Combined CD comment Responses.pdf Markup Summary

Laura Besler (10)

Bret Dilts - DPW Engineering (11)

SIGNAGE AND STRIPING PLAN

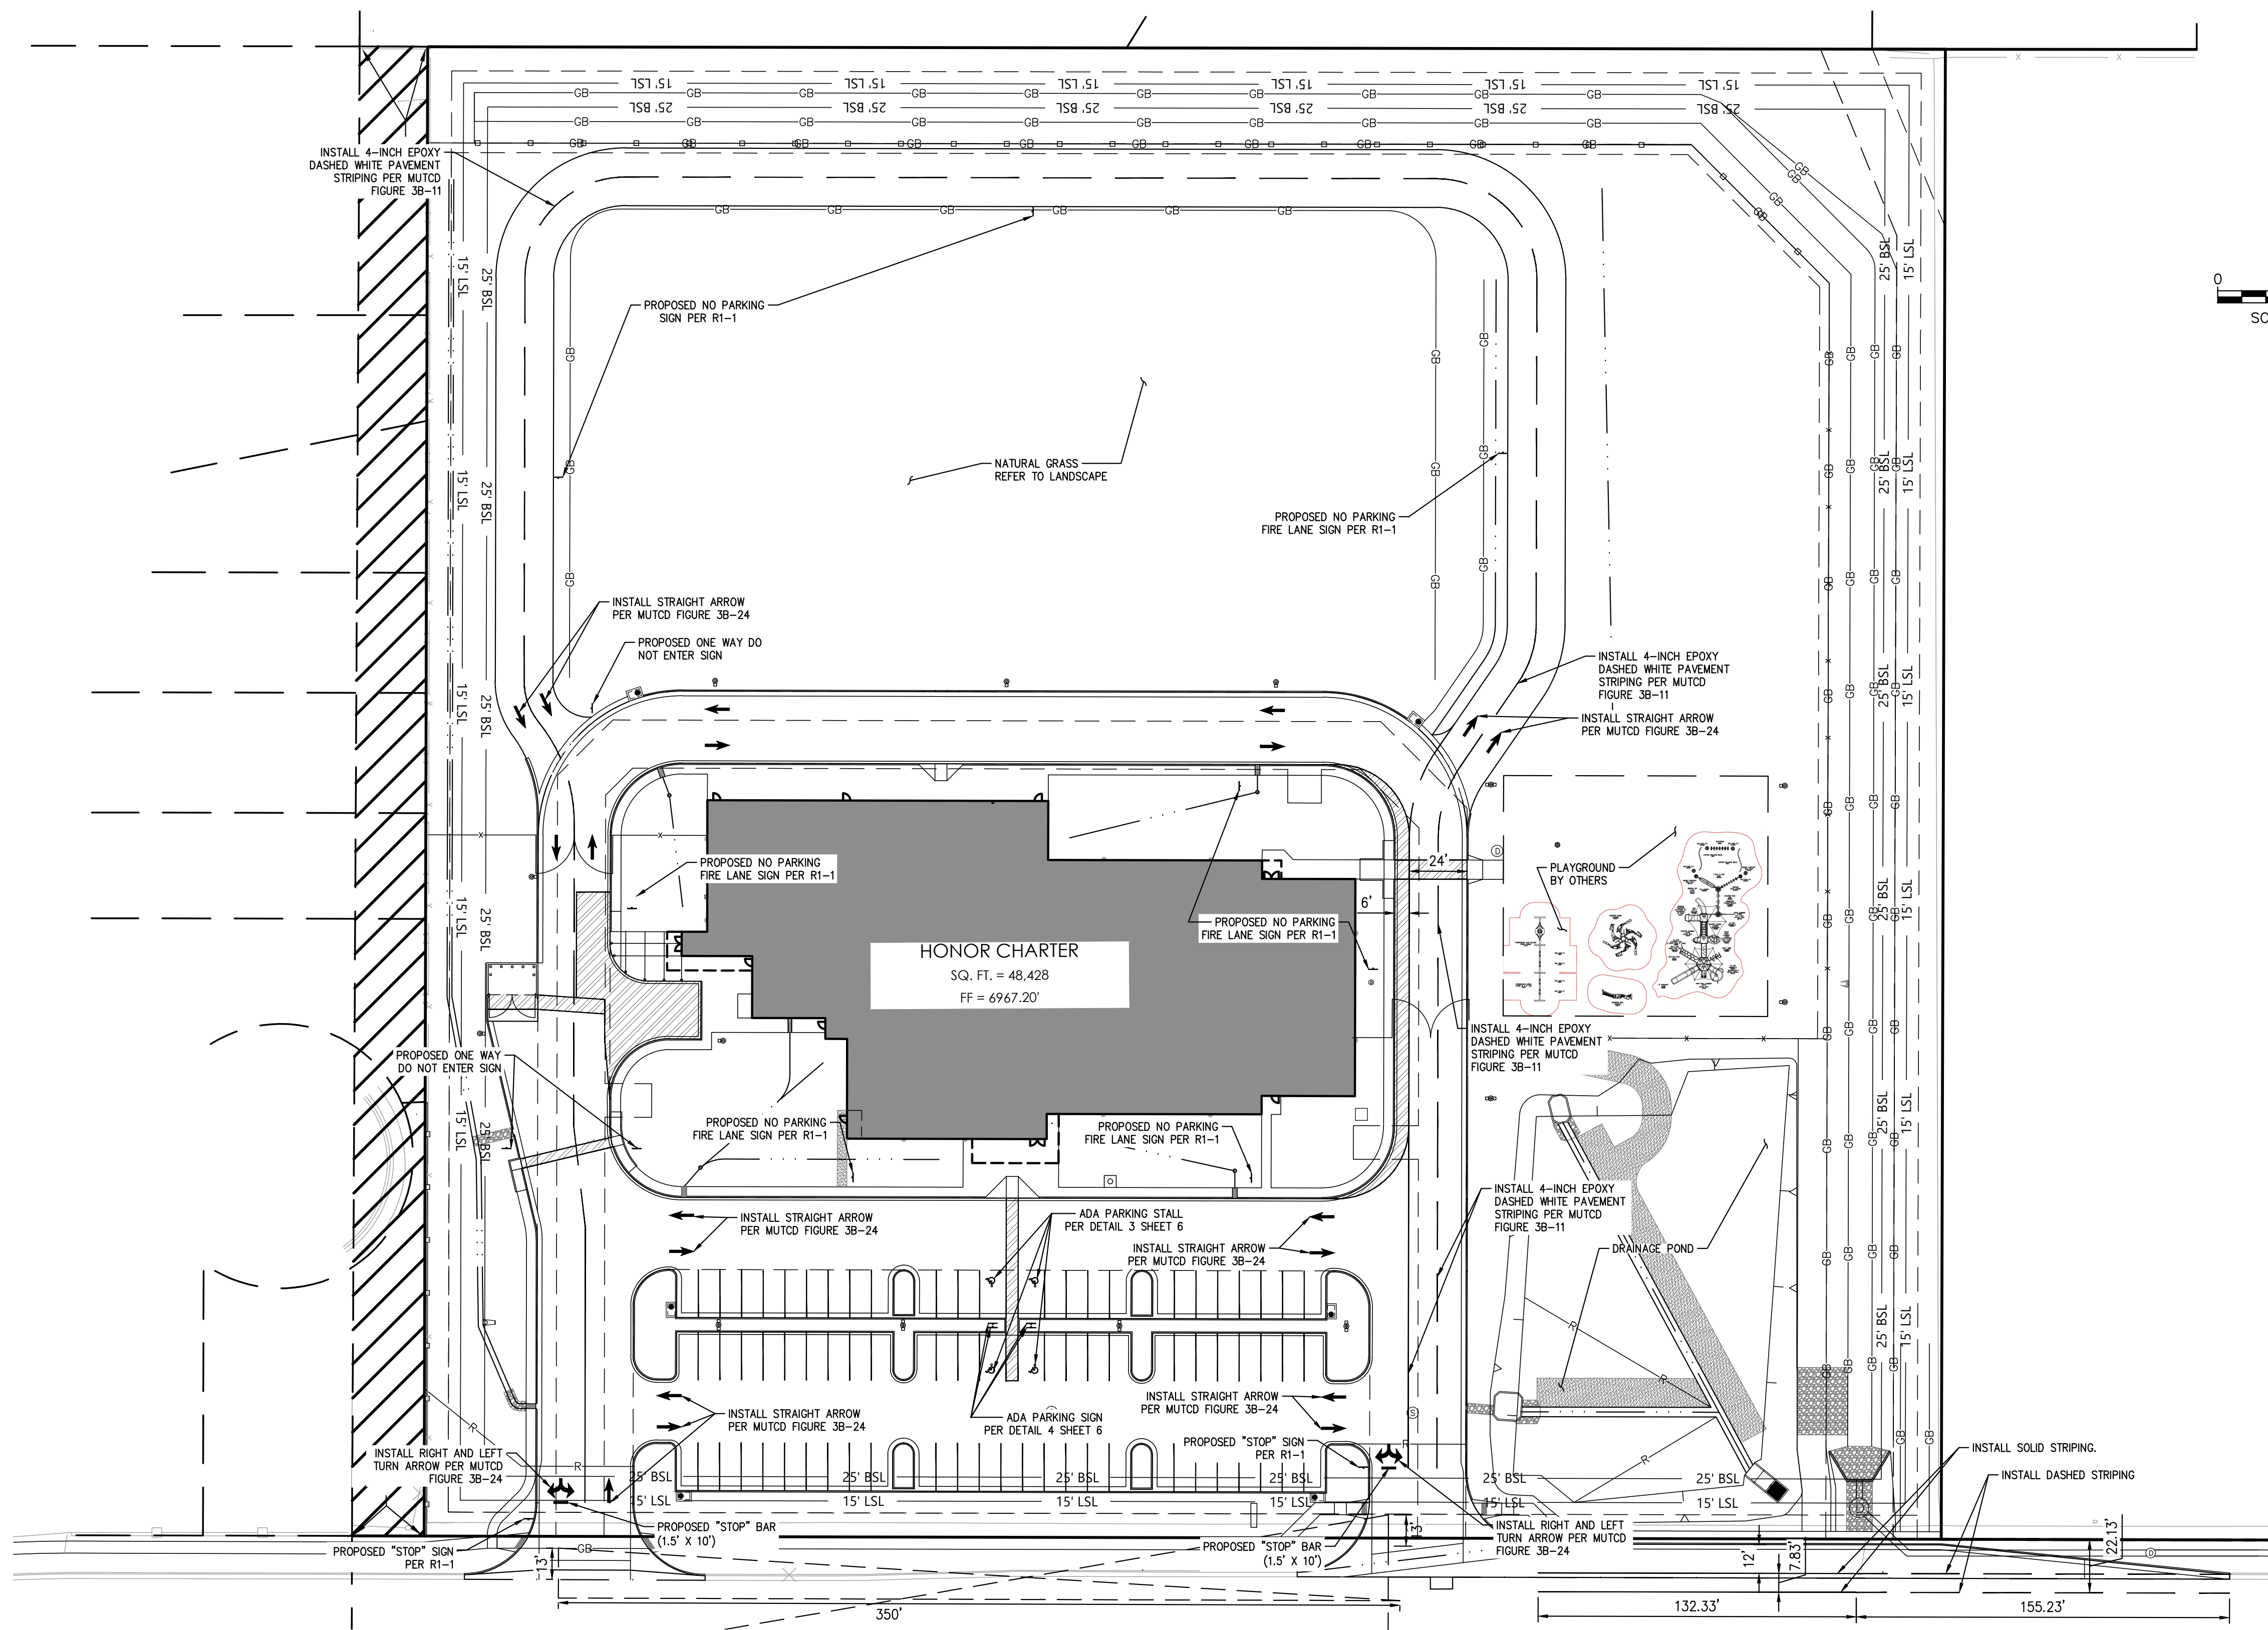
Subject: Line
Page Label: [7] 7 Signage and Striping Plan
Author: Bret Dilts - DPW Engineering

~~SD 2-20~~

Subject: Line
Page Label: [7] 7 Signage and Striping Plan
Author: Bret Dilts - DPW Engineering

MUTCD DETAIL

~~TYPICAL CURB AND GUTTER DETAILS~~

TAIT Response:
Detail was removed from Signage and Striping plan

TAIT Response:
Detail was removed from Signage and Striping plan
